Ref: SSD-67419241
Date: 18 December 2024

Re: SSD-67419241
Property: 25 – 27 Leeds Street, Rhodes

Further to Council's letter of 10 December 2024 I write to provide comments from our Waste, and Property departments on technical matters for consideration during the assessment of the subject application.

Date	Scale	Sheet Size
20.08.2024	1 : 200	@ A1
Drawn	Chk.	Job No.
JR	NH	6924
Drawing No.	Revision	
DA-1000A	/ 11

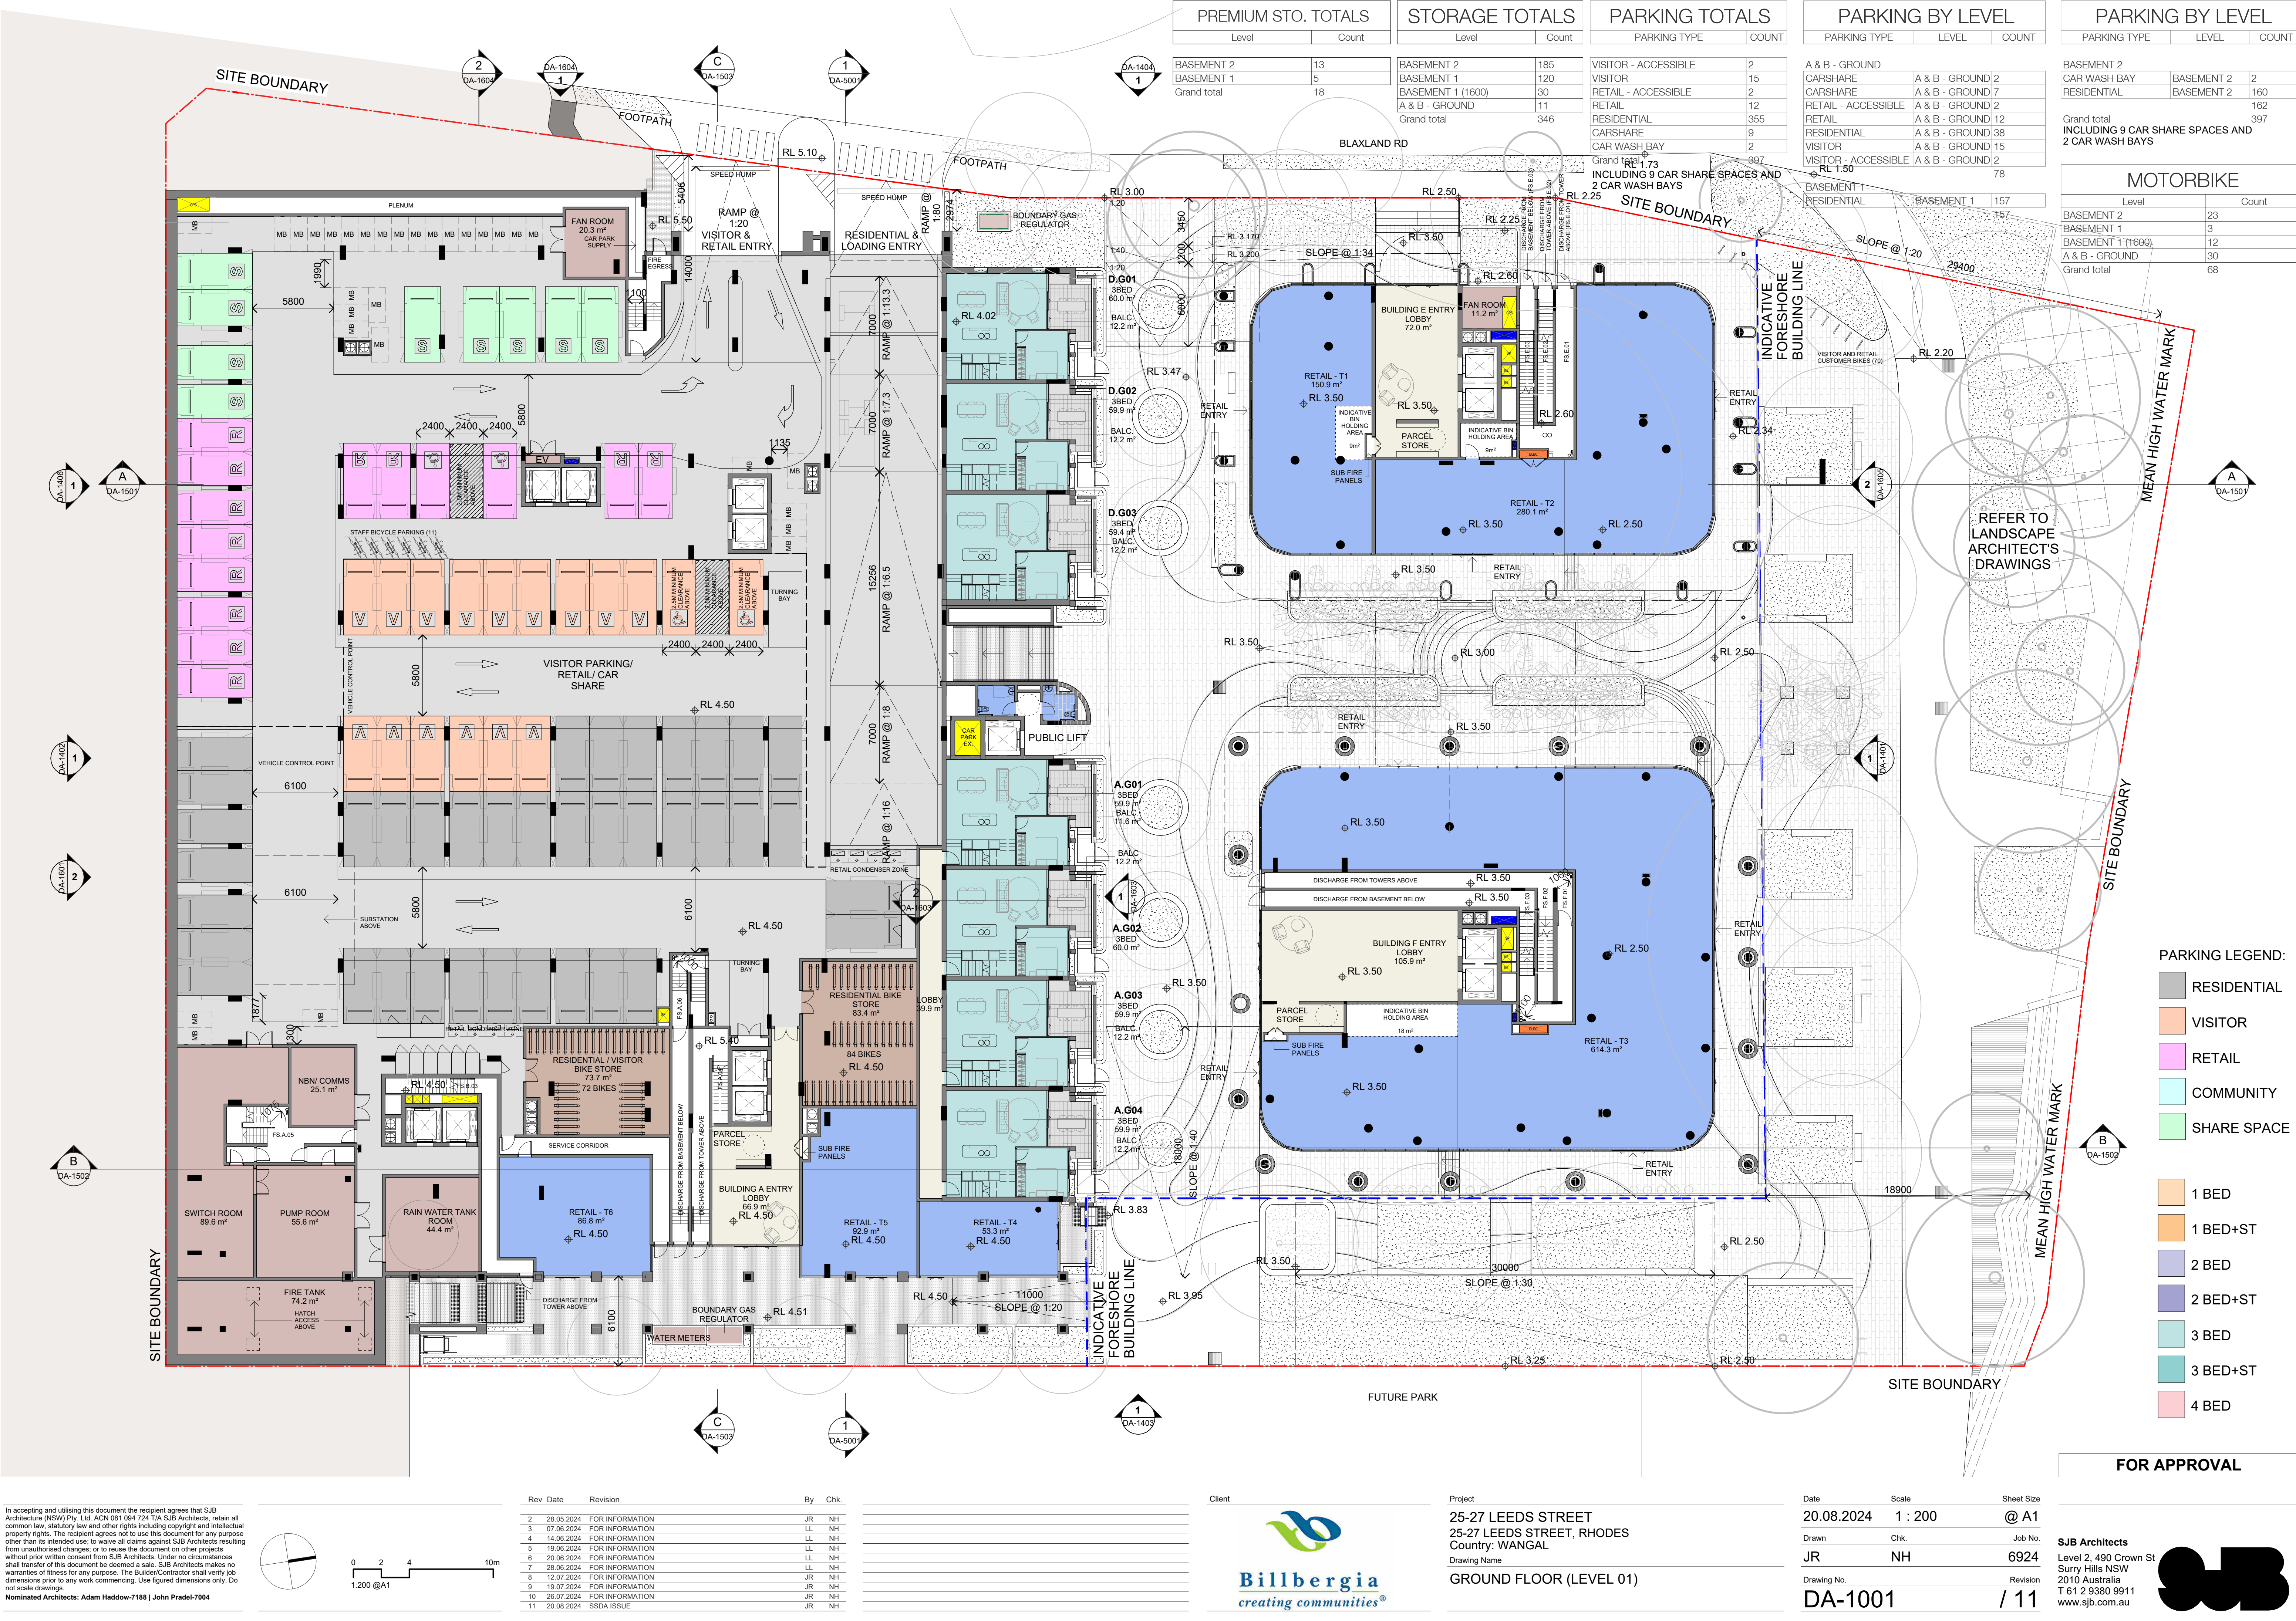
4. **Commercial Waste Bin Transfer Issues:**
The current plan shows that the commercial waste bins on Level 2 are transferred via stairs without utilizing lifts. Furthermore, the commercial waste bins on Level 1 are transferred using the residential lift, and they are also placed in the residential/visitor bike store. This is an incorrect location for the bins and the plan is lead to an incorrect location. Additionally, it appears that the transfer of commercial waste bins may involve the use of a potential residential lift in the Basement level. Please note, the transfer of commercial waste bins cannot use residential lifts.

5. **Residential Waste Room Details:**
The residential waste room on the basement level (24.4 m²), located near the larger residential waste room (199.5 m²), is missing door details on the plan. Additionally, information regarding the bin transfer between these two residential waste rooms and collection point is absent and should be included for clarity.

6. Door dimensions:
the current plan is missing door details for the waste rooms. Residential Waste Rooms should have a minimum door width of 1400 mm. Bulky Waste rooms should have a minimum door width of 1800 mm. These should be clearly shown on the architectural plans and waste management plan.
